2024/0426

11 Hardwick Grove, Dodworth, Barnsley, S75 3SS

Erection of single storey front and side extension to dwelling and erection of replacement and enlarged detached garage (Amended Description).

Drawing Title
PROPOSED ELEVATIONS

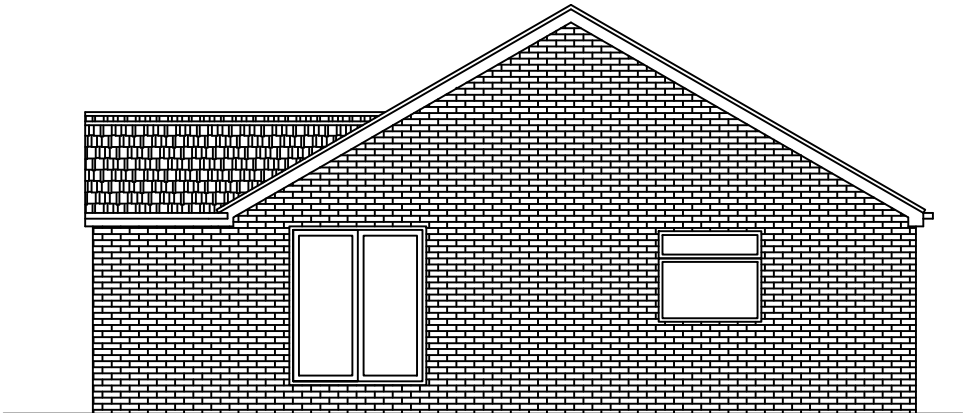
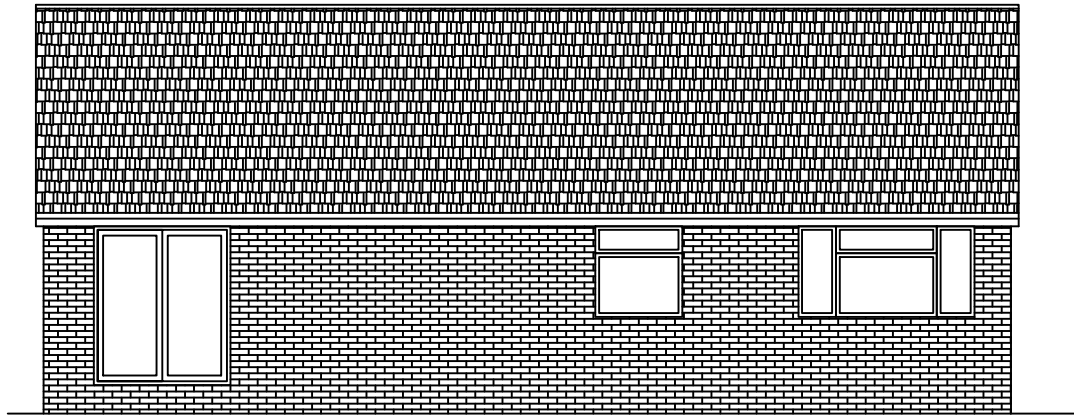
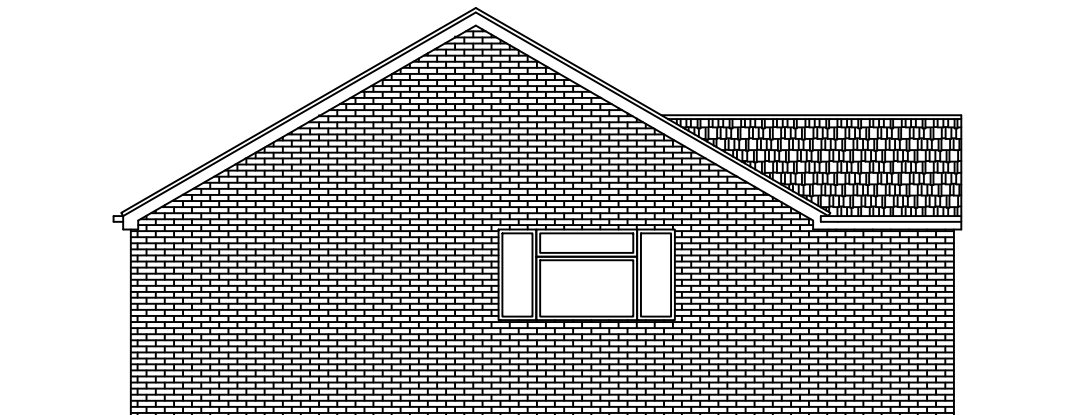
The proposed extension would project from the front (west) elevation of the application property by approximately 1.8 metres with a width of approximately 3.8 metres and a depth of approximately 10.9 metres. The extension would adopt a pitched roof with a west street-facing gable. The roof would have an approximate eaves and ridge height of 2.7 metres and 5.4 metres respectively. The gable would have a ridge height of approximately 3.9 metres. The extension would be constructed of closely matching external materials, including brickwork and roof tiles.

The proposed extension would adopt a sympathetic form and features, including a pitched roof with west-facing gable projection and closely matching external materials, including brickwork and roof tiles. In addition, the extension would not adopt an excessive sideways projection more than two thirds the width of the original dwelling and would not exceed more than half the width of the existing gap between the original dwelling and the side boundary, in accordance with the House Extensions and Other Domestic Alterations SPD.

SITE PLAN
SCALE 1:500 AT A3

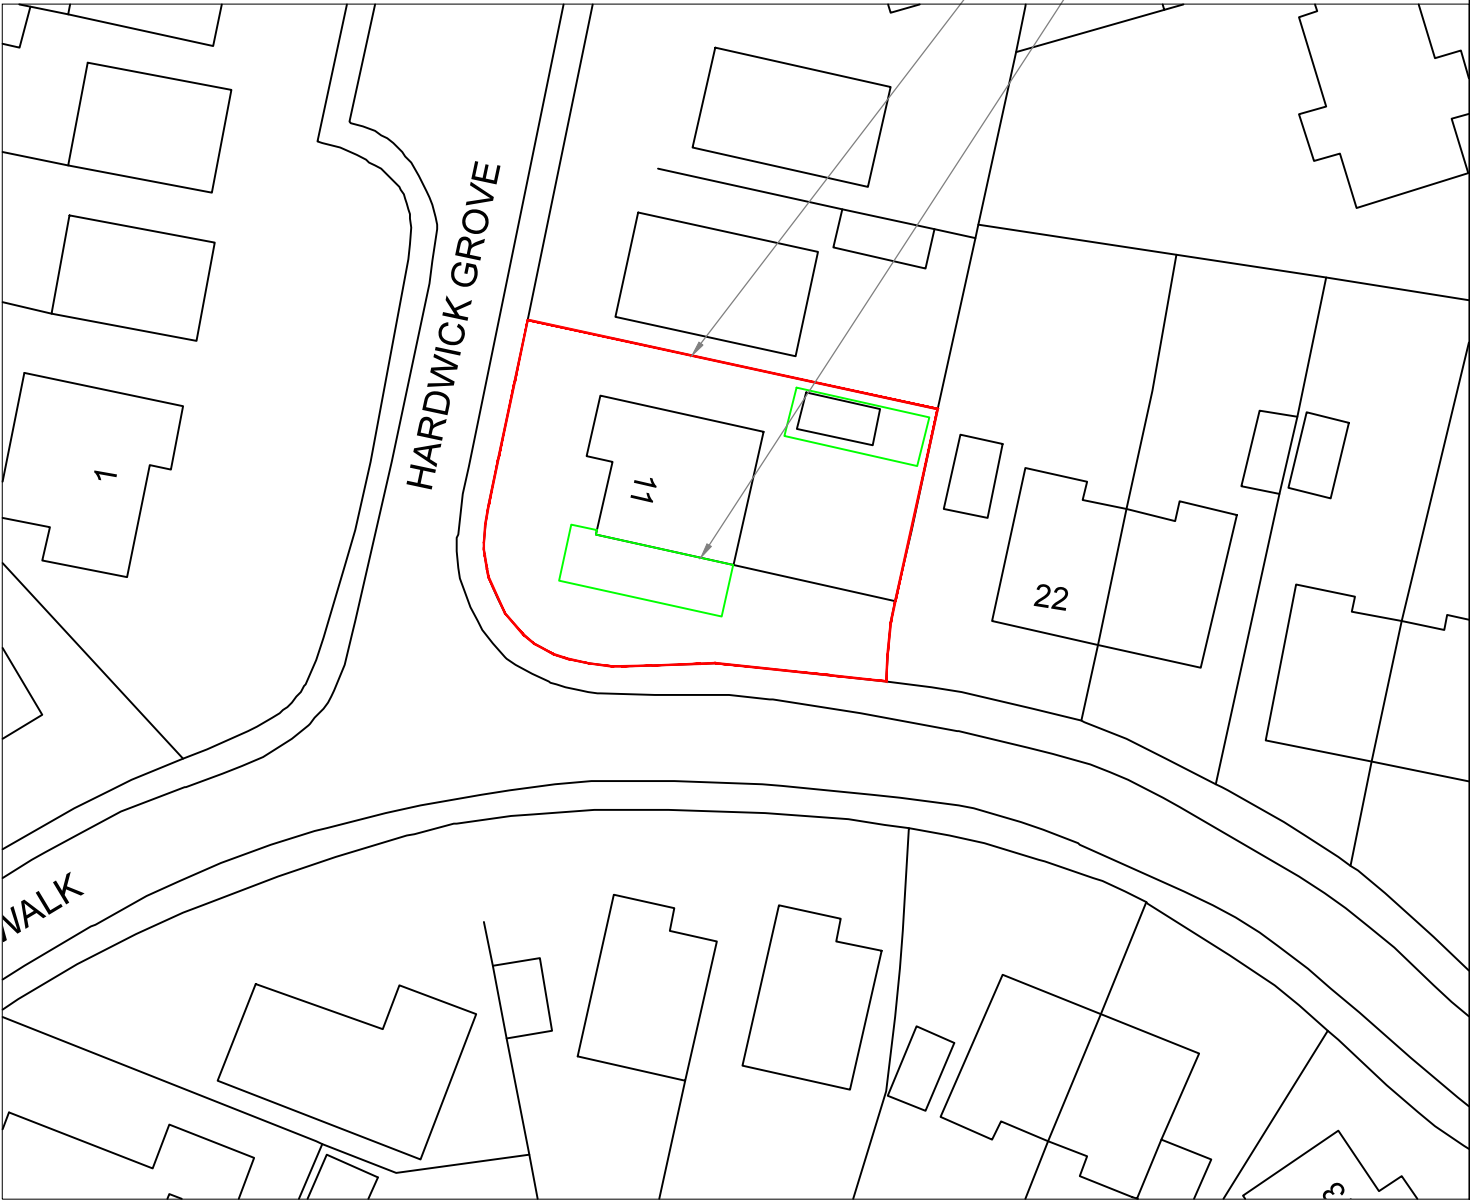
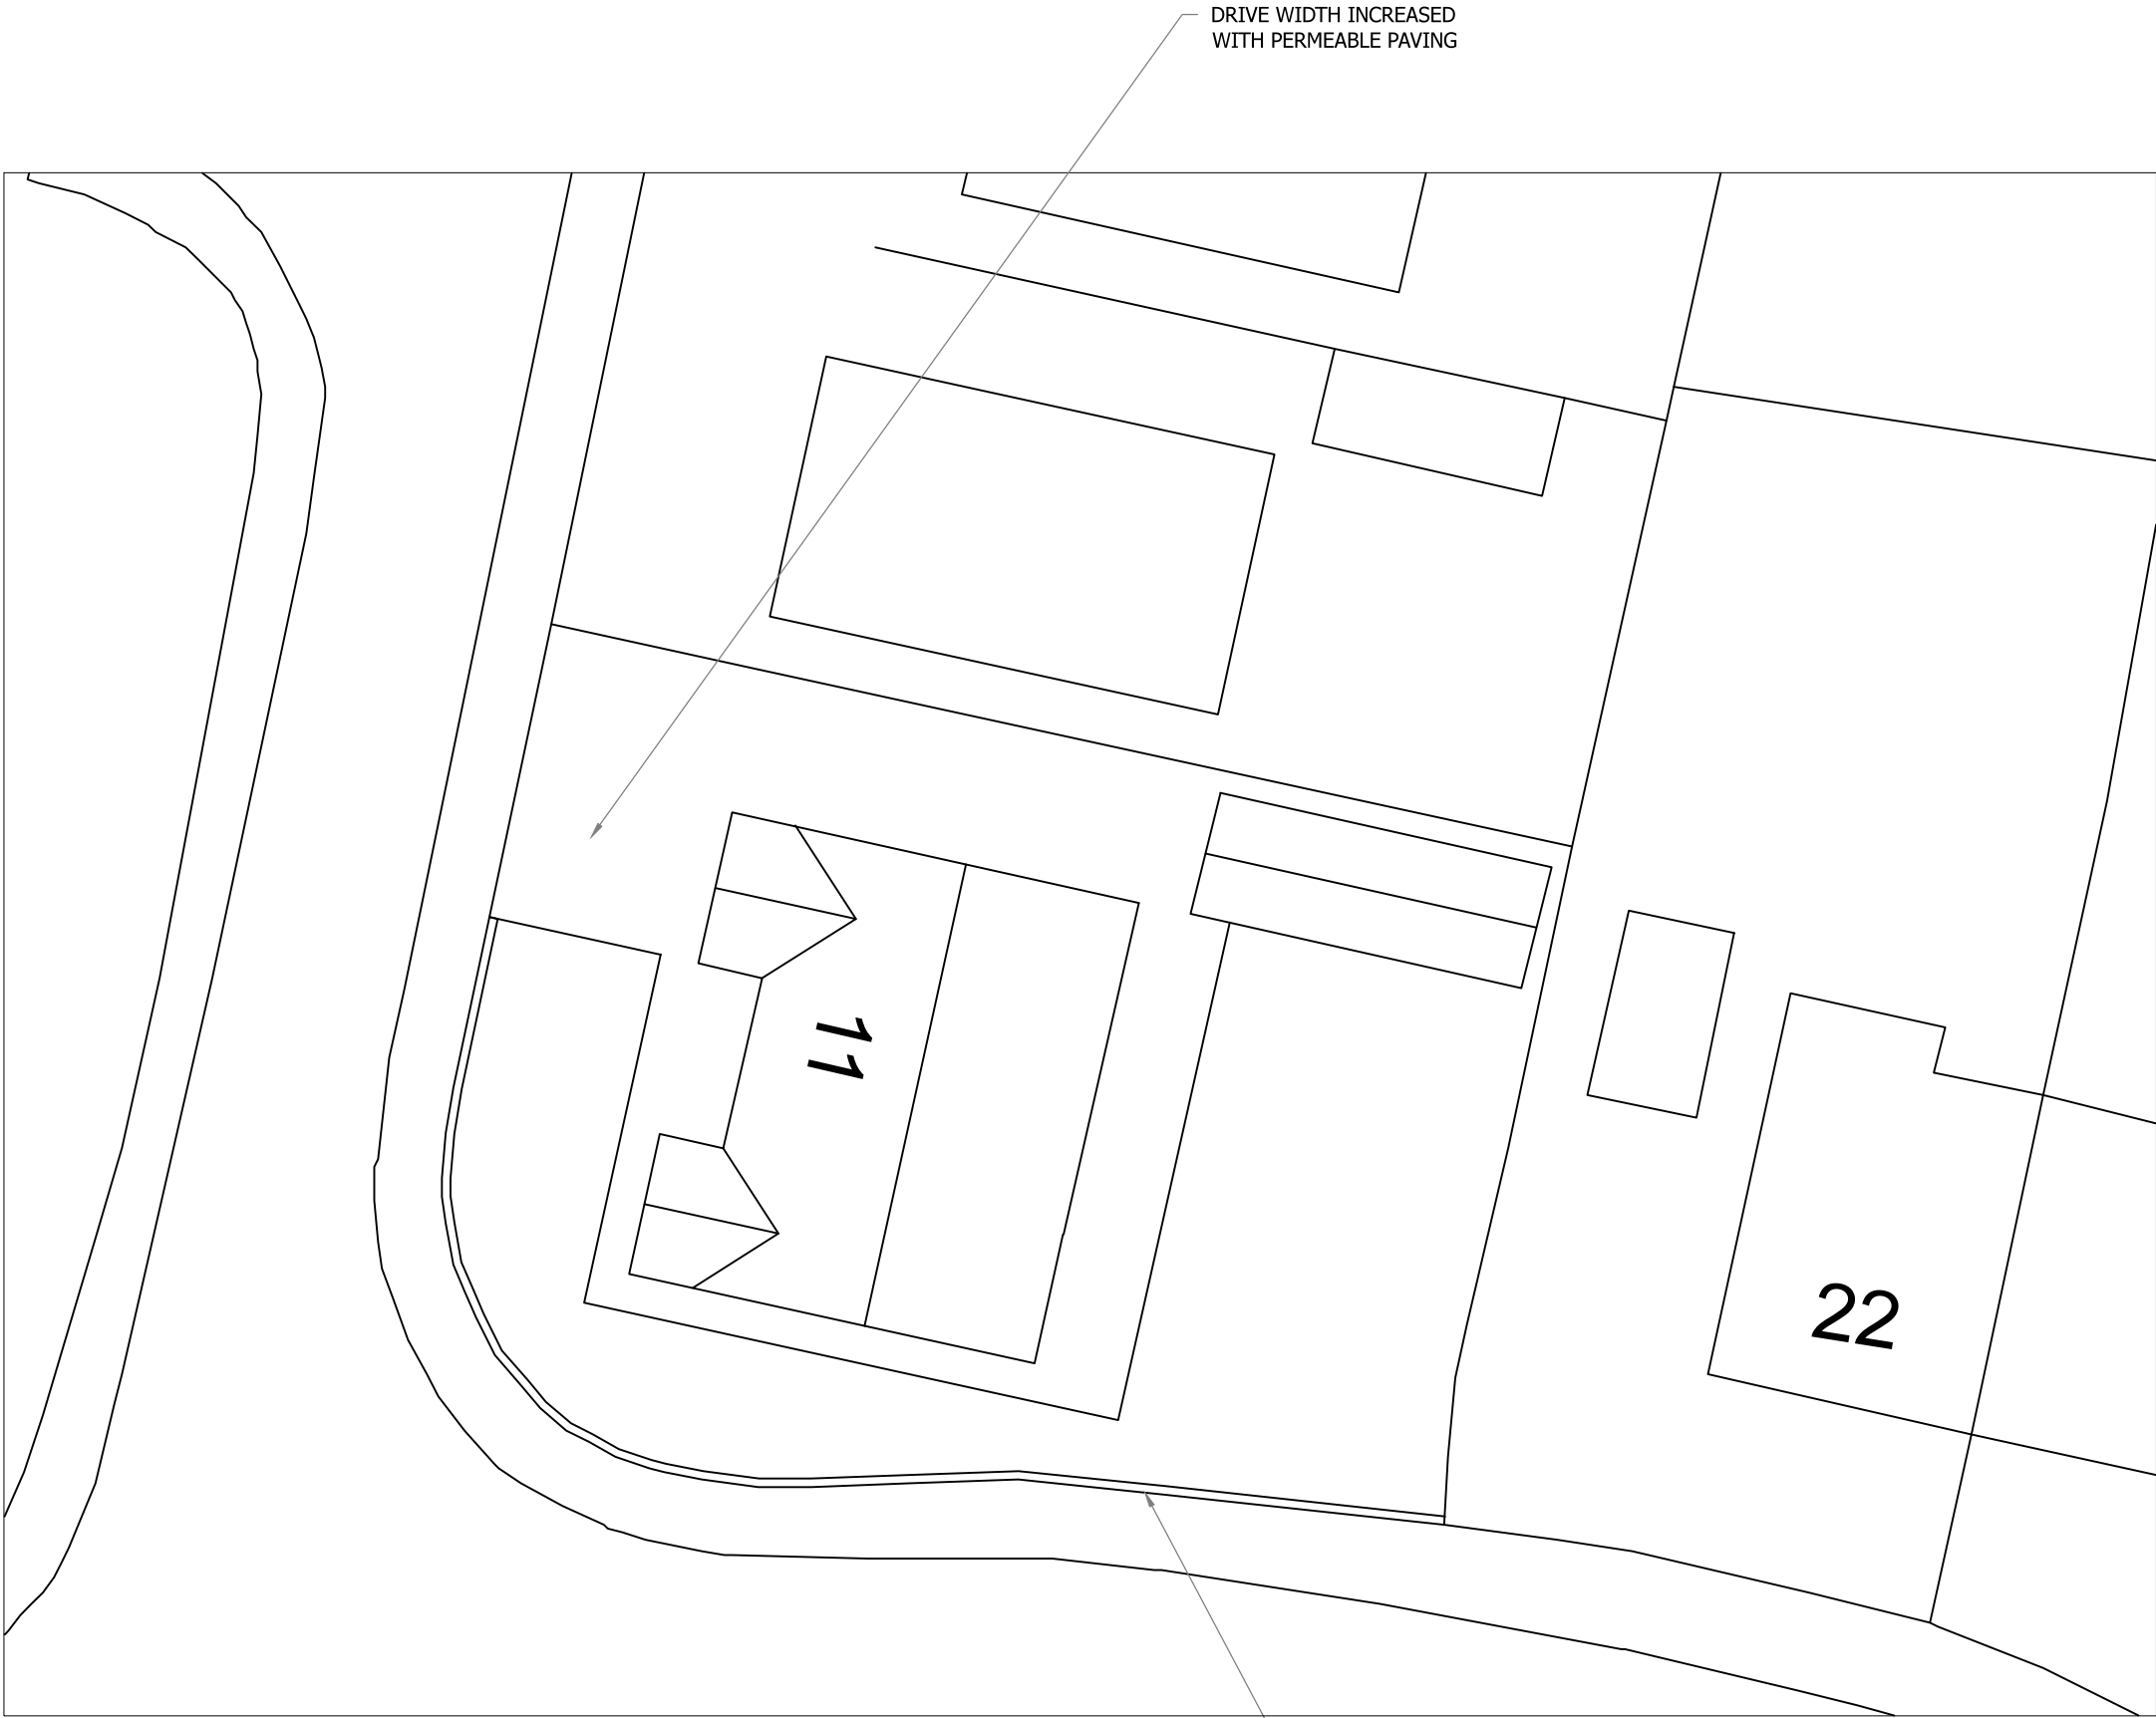
During the application process, a concern was raised in relation to the overshadowing from the pitched roof of the proposed garage. The proposed garage would be erected to the south of the rear curtilage of 10 Hardwick Grove. As such, it is acknowledged that some overshadowing could occur. However, the proposed garage has been designed in accordance with the House Extensions and Other Domestic Alterations SPD and would be erected adjacent to an existing outbuilding in the curtilage of the neighbouring property with further mitigation likely to be provided by good quality boundary treatments. In addition, the proposed garage would replace an existing garage of a similar scale and therefore, any potential overshadowing is unlikely to be significantly more harmful than any existing level of impact which could be experienced and tolerated. Furthermore, it was discussed whether a flat roof or a greater separation distance from the party boundary could be adopted to further lessen the extent of any potential impact. It is acknowledged that if a flat roof was adopted, the garage could be erected as permitted development. It was therefore decided that the garage

would be set further away from the party boundary from approximately 0.35 metres previously to approximately 0.65 metres proposed. This distance in addition to the existing distance of the neighbouring property and conservatory from the party boundary could lessen the extent of any potential impact and is therefore considered acceptable. The proposed garage will be conditioned for domestic use only.

During the application process, concerns were raised regarding a 1.5-metre-high boundary wall in that the wall would be excessive, would not be in-keeping with the nature of the estate and would appear visually heavy and stark. It was suggested that any boundary wall should be conditioned to be no more than 0.6 metres high. The applicant intends to erect a 1-metre-high boundary wall which is permitted development and therefore does not require planning permission. In addition, the issue of a covenant was raised. A covenant is a legal matter, and it is the responsibility of the applicant to ensure that they comply with all other relevant legislation or restrictions outside of the scope of the planning process.

During the application process, a 1.5-metre-high boundary wall was removed as a 1-metre-high boundary wall is intended to be erected as permitted development.

PROPOSED GROUND FLOOR PLAN
SCALE 1:100 AT A3

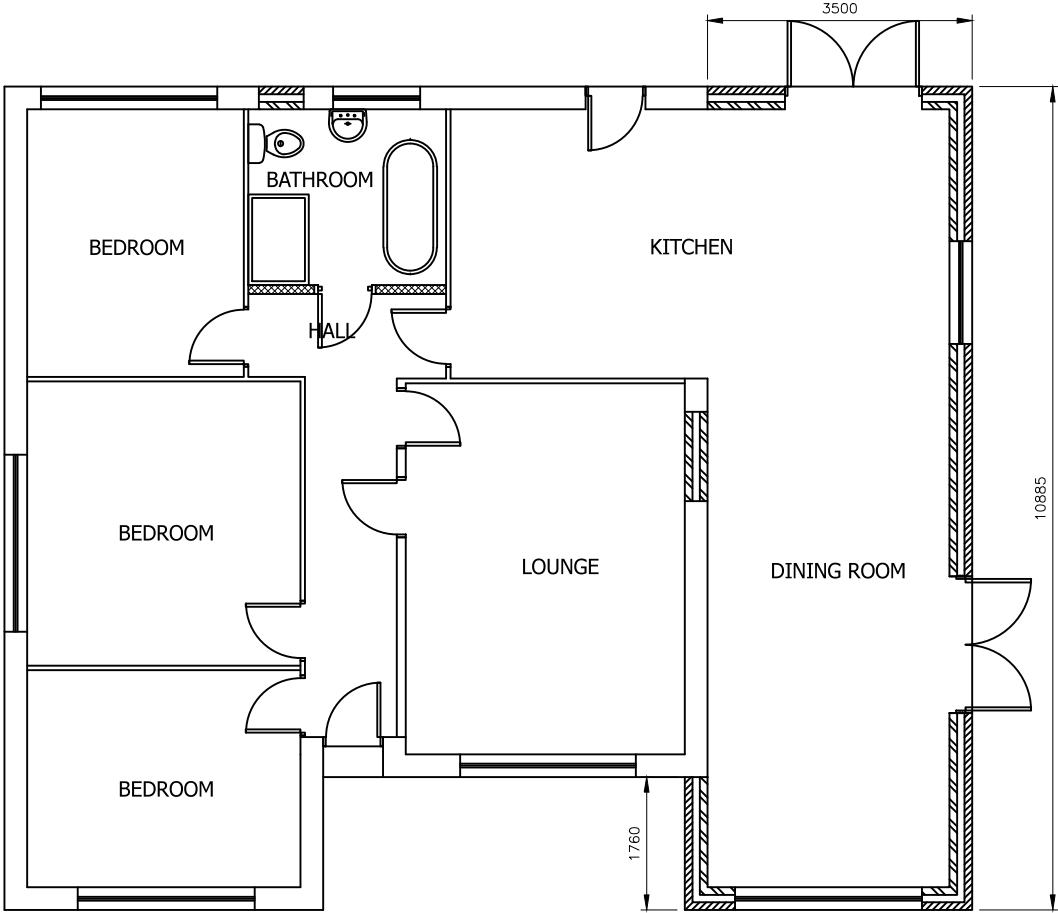
The proposed extension would be erected to the south side of the application property and would be located to the north and west of surrounding neighbouring properties. The proposed extension would not extend beyond the existing west front projection or the east rear elevation. As such, any potential overshadowing would likely be limited to the curtilage of the application property. The proposal would not result in reduced levels of outlook.

The proposed extension would feature glazing on all elevations. It is acknowledged that the proposal would not comply with required separation distances to the east and south, contrary to the House Extensions and Other Domestic Alterations SPD. However, existing boundary treatments to the east and ground level differences to the south would likely provide an acceptable degree of mitigation that could lessen the extent of any potential impact. The garage would not feature any glazing.

Client	DANIEL CROSSLEY
Drawing Title	GARAGE PLANS
Address	11 HARDWICK GROVE DODWORTH S753SS

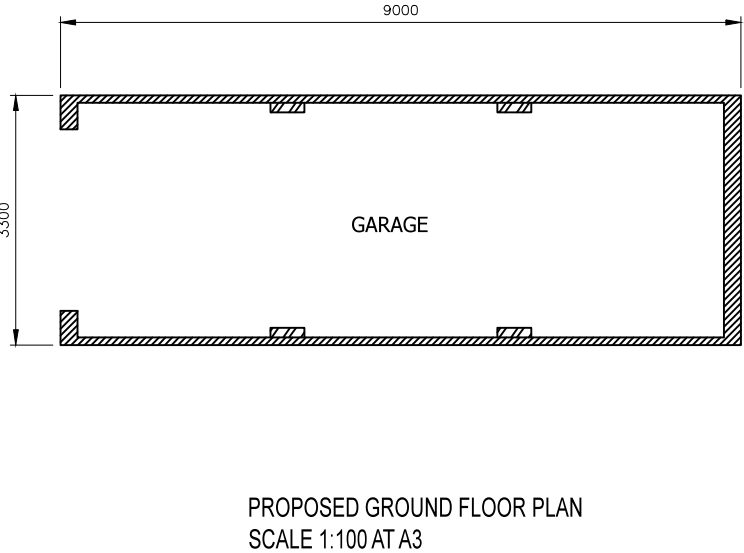
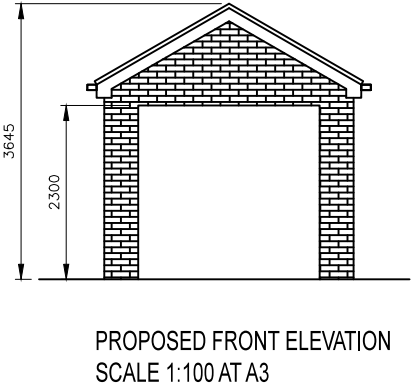
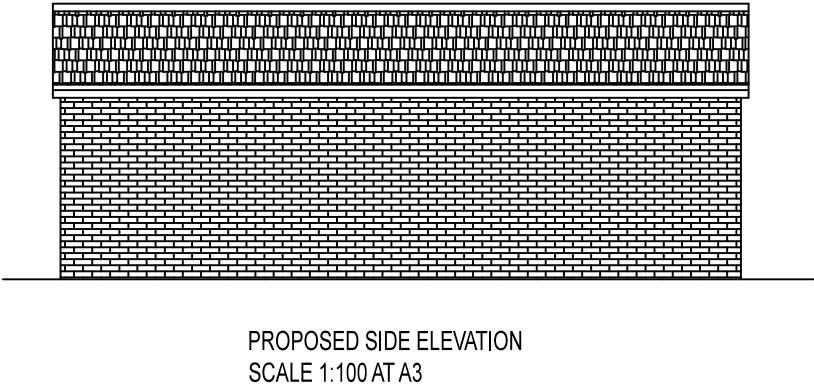
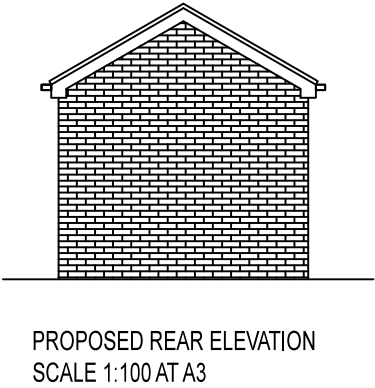
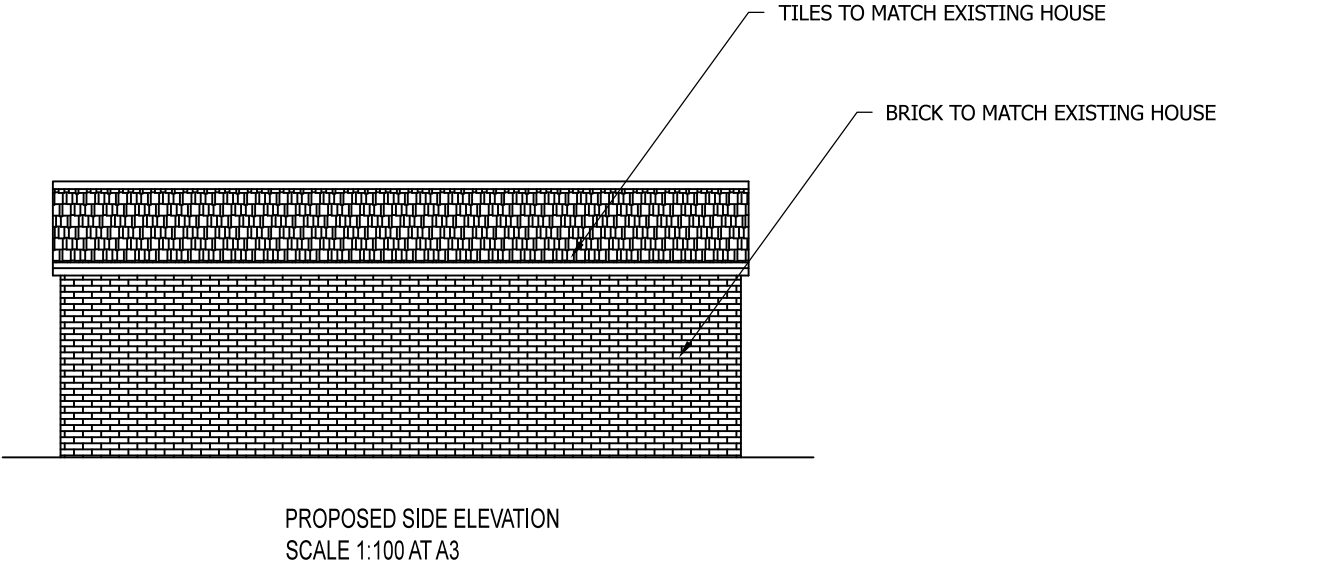
The proposed garage would measure approximately 3.3 metres by 9 metres and would adopt a gable roof with an approximate eaves and ridge height of 2.6 metres and 3.6 metres respectively. The garage would be constructed of closely matching external materials, including brickwork and roof tiles.

The proposed garage would adopt a sympathetic form and features, including a gable roof, and closely matching external materials comprising brickwork and roof tiles. The proposed garage would be significantly set back from the highway and would not be an overly prominent or dominant feature
